Subject: RE: Planning Consultation on AL/28/20/DOC

Surface water drainage;

APPLICATION NO: AL/28/20/DOC

Site Address: Land To South Of Barnside Hook Lane Aldingbourne PO20 3TE

P4	11.09.19	AMENDED TO SUIT WSSC COMMENTS.	PJM
P3	15.07.19	NOTE TO TELEPHONE POLE ADDED.	JMB
P2	01.07.19	EXTENT OF WORKS AMENDED.	JMB
P1	14.06.19	PRELIMINARY ISSUE FOR COMMENT	JMB
Revision	Date	Description	By

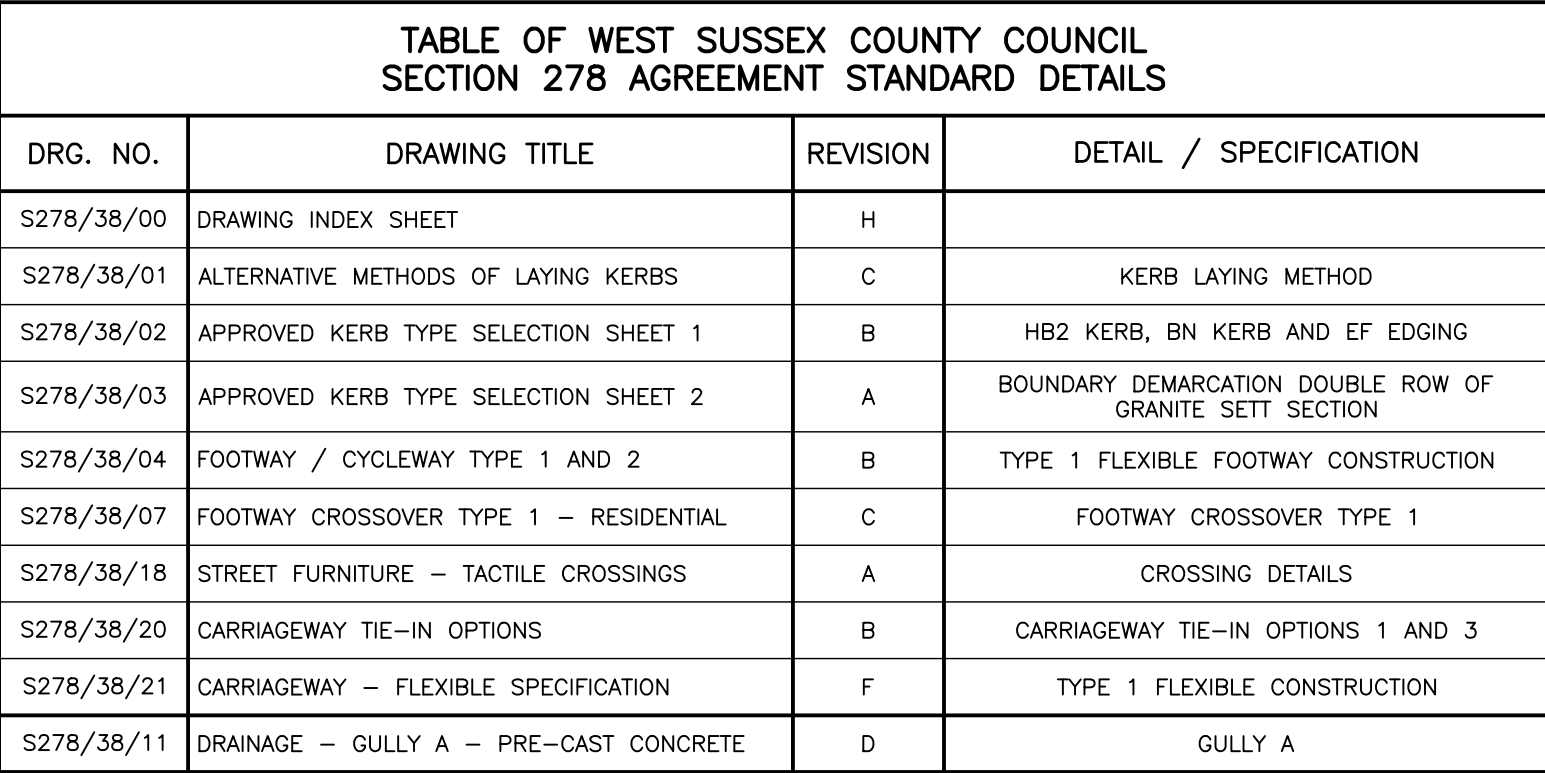
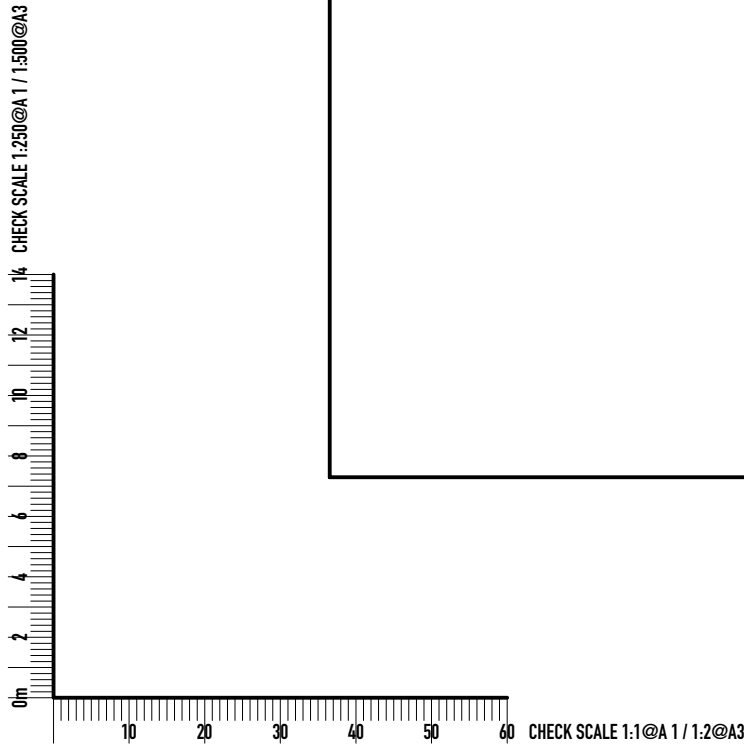
It is noted that this is a pre-occupation condition and is very likely that the drainage has already been installed. It is unclear as to whether the layout drawing provided is 'as constructed' or proposed. Please confirm which is the case as there is little point in just changing drawings to suit the comments below, works on site may also be required. Therefore, a site inspection will be required to review some elements.

1. Reference is made to my former colleague Laura Gibbons agreeing the detailed scheme, please provide evidence.
2. Provide supporting groundwater monitoring and percolation testing data.

3. Provide hydraulic flow calculations.
4. SA10 is very close to the pond bank and could cause stability issues. Please advise.
5. Pipes not connecting to manholes to connect via oblique 45 degree junctions.

6. Indicate manhole invert levels at all manholes/rodding eyes/tanks (outlets) & headwalls (inlets/outlets).
7. Provide pipe diameters on pond outlet.
8. Provide manufacturers technical details of hydrobrake/discharge rate.

9. Silt traps (catchpit manholes) to be provided immediately upstream of all soakaways.
10. ACO drain rear of plot 2 is connecting against the flow.
11. What work has been carried out to the existing pond in terms of maintenance? Ordnance survey showed an existing outlet on the south side of the pond – what has happened to this?

12. The inlets and outlets associated with the pond and ditch require Land Drainage consent. If this work has already been carried out then the applicant is in breach of the Land Drainage Act 1991, since no consent has been given. Please advise.

13. There appears to be no permeable paving to improve water quality just a petrol interceptor. Was this agreed? – provide evidence.
14. Ponds inlet at S2 – 90 degree pipe configuration – pipe angle should be increased to provide better flow arrangement.

16. Full construction details of all drainage elements are required. These are to include; headwalls, soakaways, manholes including catchpits, gullies, channel drains, control hydrobrake manhole, petrol interceptor, pipe bedding, etc.
